3 June 2025

RE: SSD-79276958 Residential development with infill affordable housing, 59-63 Trafalgar Avenue 1A&1B Valley Road Lindfield

Please find accompanying the reasons for my objection to this Landmark Group residential development. In addition to this being an inappropriate development for its location, there exist a number of inaccuracies in Landmark's Environment Impact Statement (EIS).

Existing site photo - Middle Harbour Road and Trafalgar Avenue.

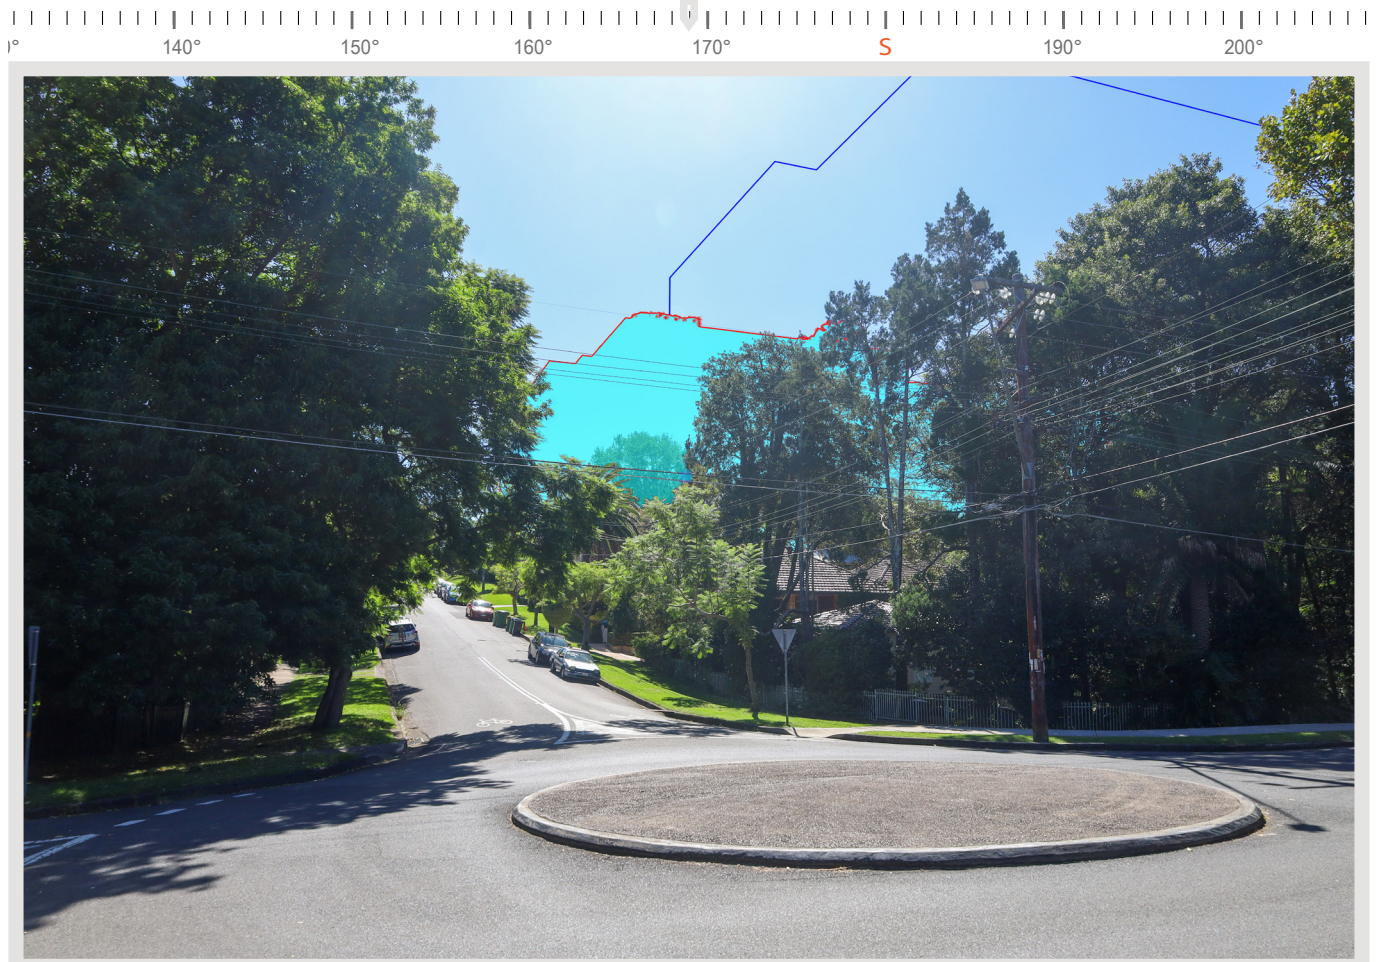
Please see the accompanying photos in Appendix A that highlight the impact of the size of the development from the surrounding streets of Middle Harbour Road, Russell Avenue, Valley Road, Nelson Road, up to 9 metres below the site ground level.

It is clear that the Visual Impact Report from Urbaine is inaccurate and misleading, as it purports to show the visual impact of a 4-storey building, not 9+ storeys.

Figure 2 Location map showing the subject site outlined in red

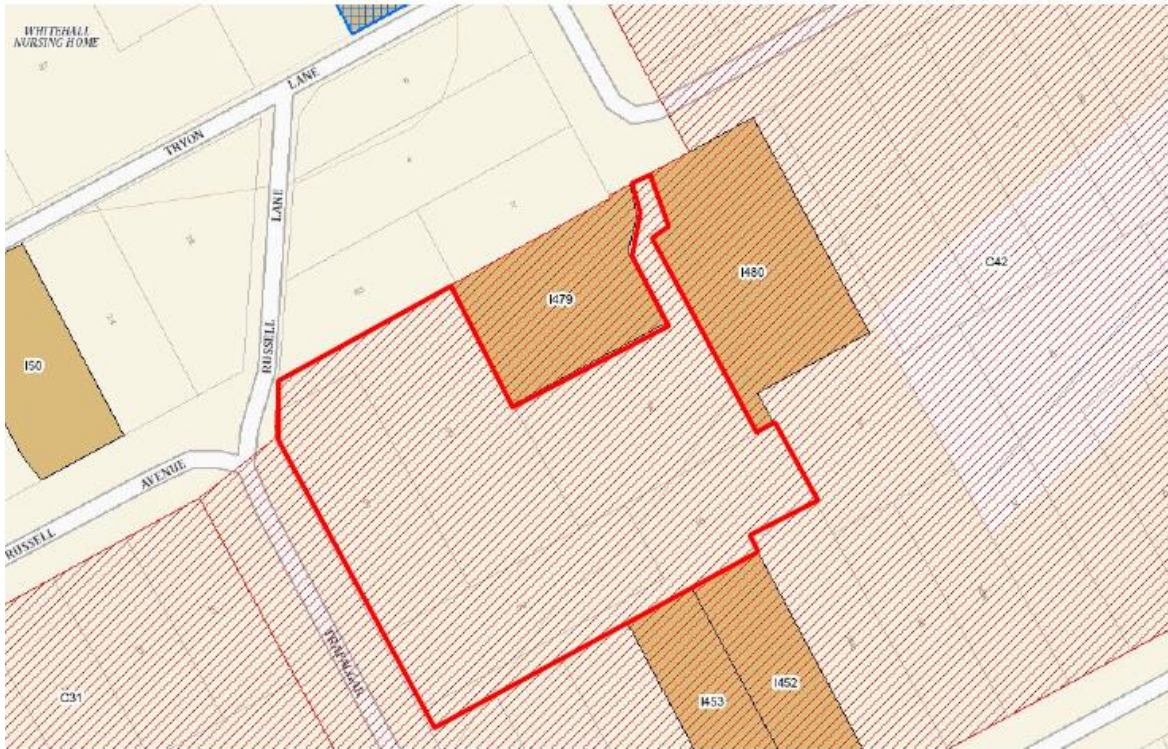
The proposed site abuts four heritage items as shown in the diagram below.

- Fails to provide a review of the two HCAs as to the significance of the loss of these buildings to the overall HCA.
- The proposal will severely negatively impact the Middle Harbour Road HCA as this proposal is central to 4 heritage items (1 and 3 Valley Rd, 32A and 34 Middle Harbour Rd) with another item at 6 Valley Road only 50 metres from the development.

- Fails to thoroughly assess the impact of this development on the three heritage items abutting the development in terms of shadow, overlooking, gardens and landscaping and the 6 other heritage items within close proximity.

- Fails to address the lack of adequate setback and landscape requirements for developments adjoining heritage items as stated in the Ku-ring-gai Development Control Plan(DCP) section 19F and 19D.
